One Earth Solar Farm

Draft Statement of Common Ground with Historic England

EN010159/APP/8.7.21

October-November 2025

Viewpoint 26b      View from Fledborough Viaduct, west of the River Trent (Winter)

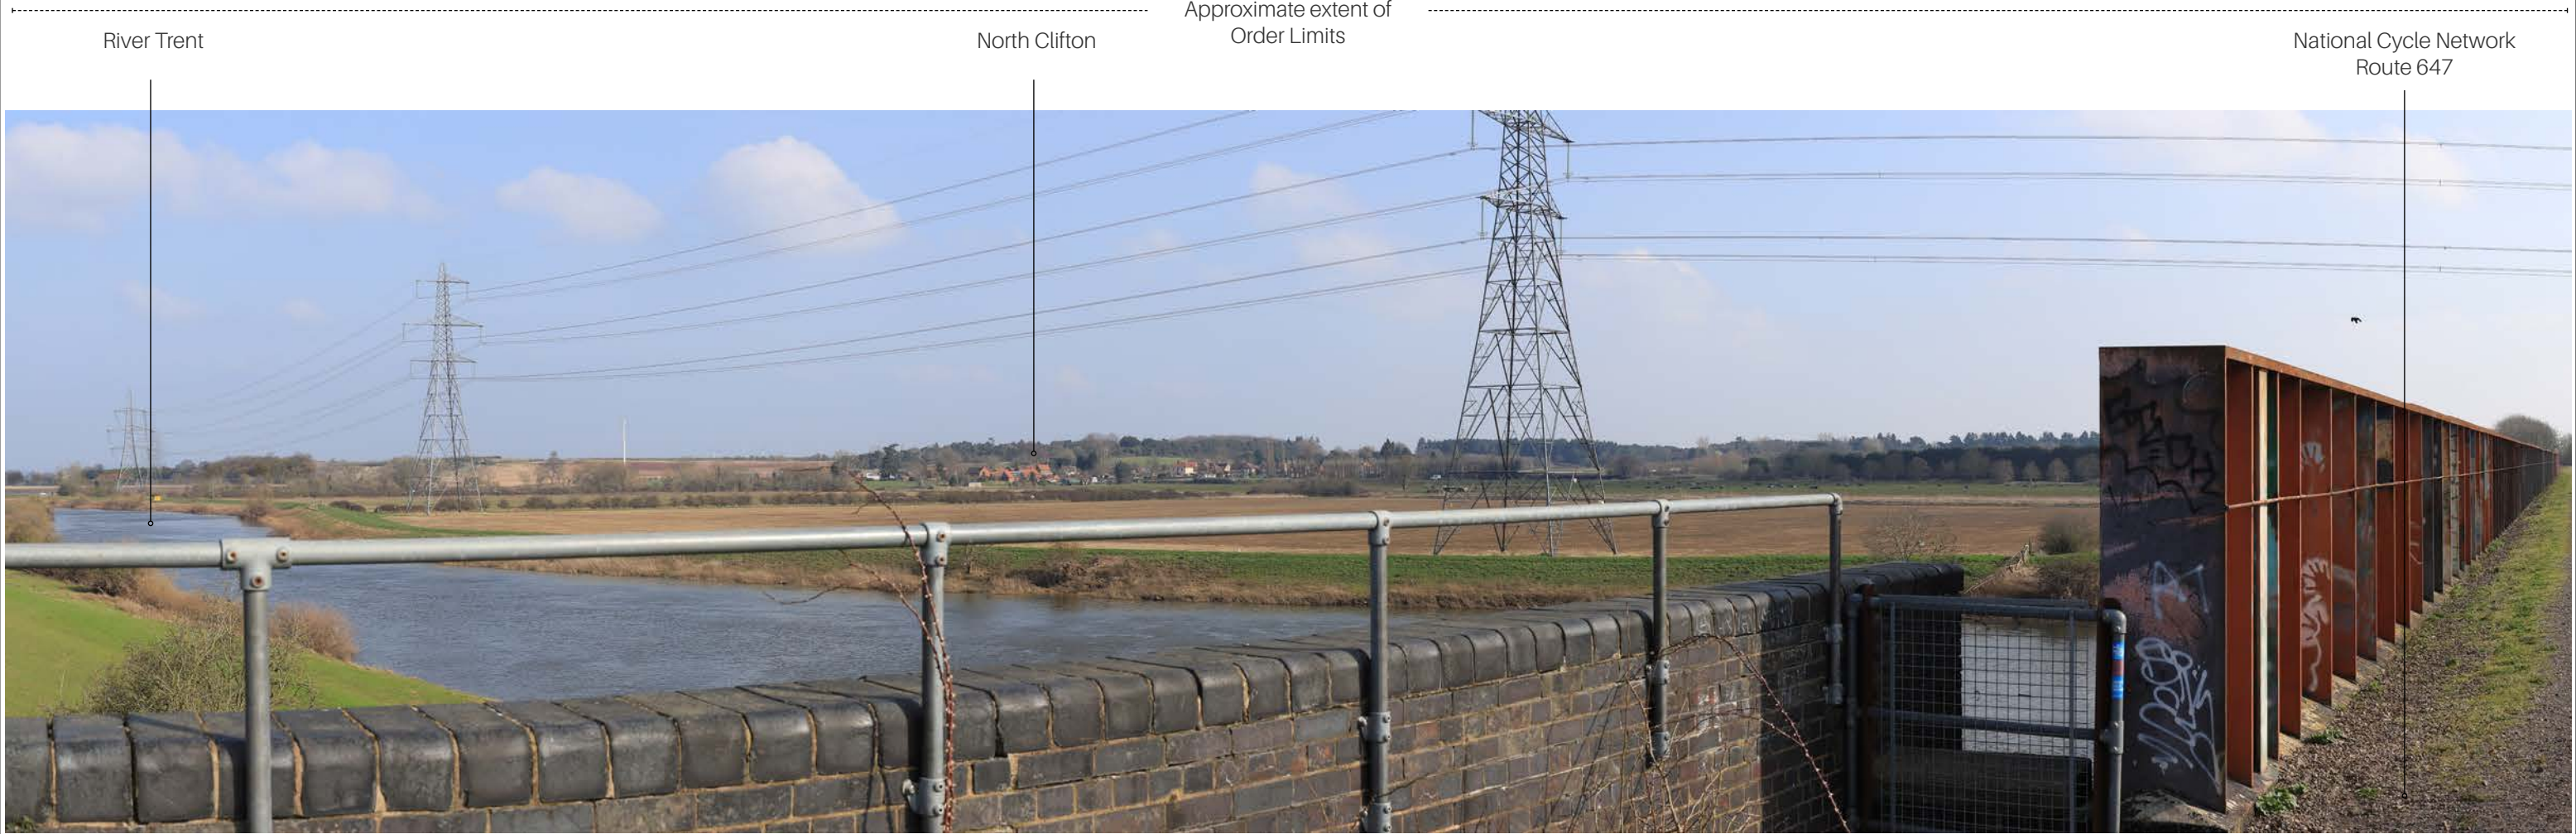
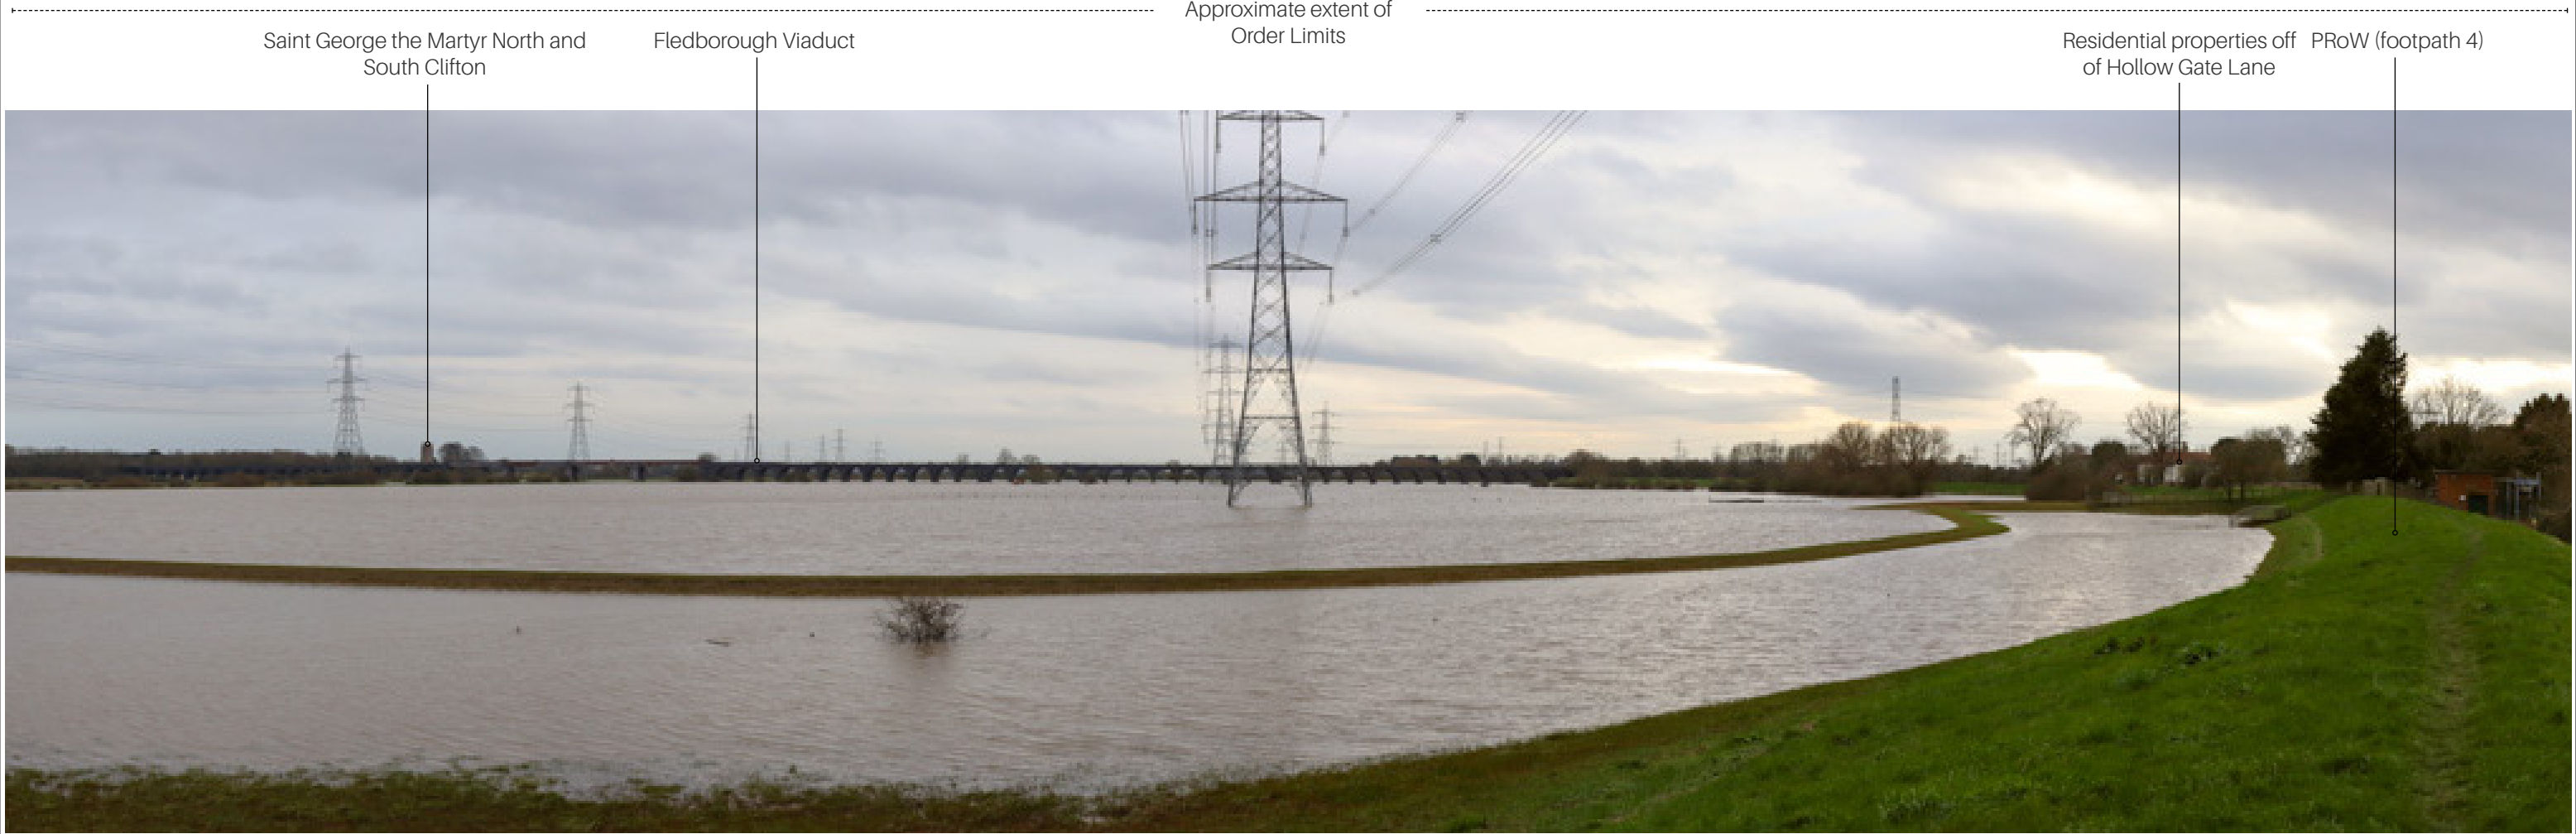
confirmed in subsequent response to Relevant Representation, there would be no impact to the Church.	
02-06	Impact on built heritage assets	<p>Further understanding required on field to the north of North and South Clifton as viewed from Fledborough Viaduct.</p> <p>Further detail can be found in Historic England's Relevant Representation [RR-019, 190], as well as email correspondence in December 2024 – January 2025.</p>	<p>The understanding of Proposed Development in relation to North and South Clifton is supported by LVIA photomontages (Views 25a, Figure 11.13.7a, [AS-038]) and Zone of Theoretical Visibility (Figure 10.3 [APP-055]). The effect on heritage assets within North and South Clifton is provided in pages 51-53 and page 57 of ES Chapter 10 [APP-039]. There are no harmful effects identified to these assets.</p>	Under Discussion
02-07	Mitigation	<p>Historic England have requested for mitigation to be provided at western substation (Gibraltar Farm) and consideration of associated impacts, i.e. lighting.</p> <p>Further detail can be found in Historic England's Relevant Representation [RR-019, 190], as well as email correspondence</p>	<p>The mitigation for Gibraltar Farm has been clarified at 10.5.5 of ES Chapter 10 [APP-039], and the assessment has been provided at 10.6.65 - 67. The mitigation provided is considered to be proportionate to the very low value of this asset. And this location is considered preferable to others, as per the response to comment 02-HE02 above.</p>	Under Discussion
